WAMBO COAL PTY LTD

NORTH WAMBO UNDERGROUND MINE LONGWALL 10A MODIFICATION

RESPONSE TO SUBMISSIONS

FOR THE MODIFICATION OF DA 305-7-2003 (MOD 14)
THE ADDITION OF NORTH WAMBO UNDERGROUND MINE LONGWALL 10A

Figure 1: Location of Proposed Longwall 10A

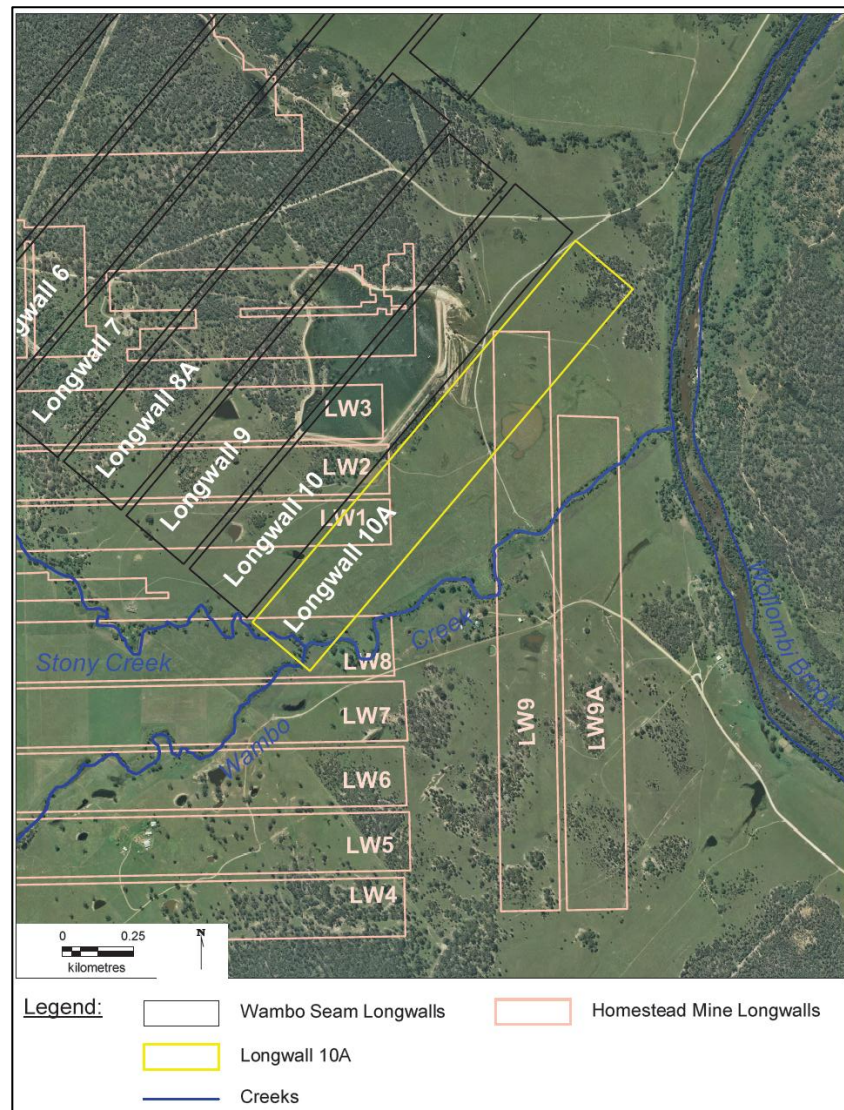
As an outcome of the submissions, WCPL has considered the costs and benefits associated with implementing a standoff of the proposed Longwall 10A from the Wambo Creek channel.

WCPL has assessed the implications of reducing the length of proposed Longwall 10A by 245 metres (m) to avoid directly undermining the Wambo Creek and Stony Creek channels by the proposed Longwall 10A (i.e. reducing the length from 1,745 m to 1,500 m) (Figure 1). These implications would include:

- Sterilisation of 262,000 tonnes of ROM coal, equivalent to 14% of the total ROM coal that could be recovered from the proposed Longwall 10A.
- Lost revenue to WCPL in the order of \$13.5 million at 2014 pricing.
- Lost royalties to the state of NSW of approximately \$0.9 million.

- Potential for operational discontinuity in the order of 3 weeks.
- Reduction in additional total subsidence on the relevant section of Wambo Creek from 2,400 mm to 1,600 mm (i.e. in addition to the previous subsidence that has already occurred as a result of mining in the Whybrow Seam). This would result in a maximum gradient along this section of Wambo Creek prior to remediation of 2.2% compared to 3.8% with the extraction of the proposed Longwall 10A.

- Reduction in additional total subsidence on the relevant section of Stony Creek from 1,500 mm to 1,000 mm (i.e. in addition to the previous subsidence that has already occurred as a result of mining in the Whybrow Seam). This would result in a maximum gradient along this section of Wambo Creek prior to remediation of 1.7% compared to 2.2% with the extraction of the proposed Longwall 10A.

WCPL does not consider the above alternative is justified given:

- Wambo Creek and Stony Creek have been previously undermined by the Homestead and Wollemi Mines in the Whybrow Seam, including at this location.
- The section of Wambo Creek and Stony Creek above the proposed Longwall 10A is approved to be undermined in two additional seams by the Arrowfield and Bowfield Underground Mines.

- The assessment by Evans & Peck (2014) concluded that the prompt implementation of any necessary mitigation works would minimise the risk of any change in sediment movement along Wambo Creek or upstream migration of head-cuts along both Wambo Creek and Stony Creek.
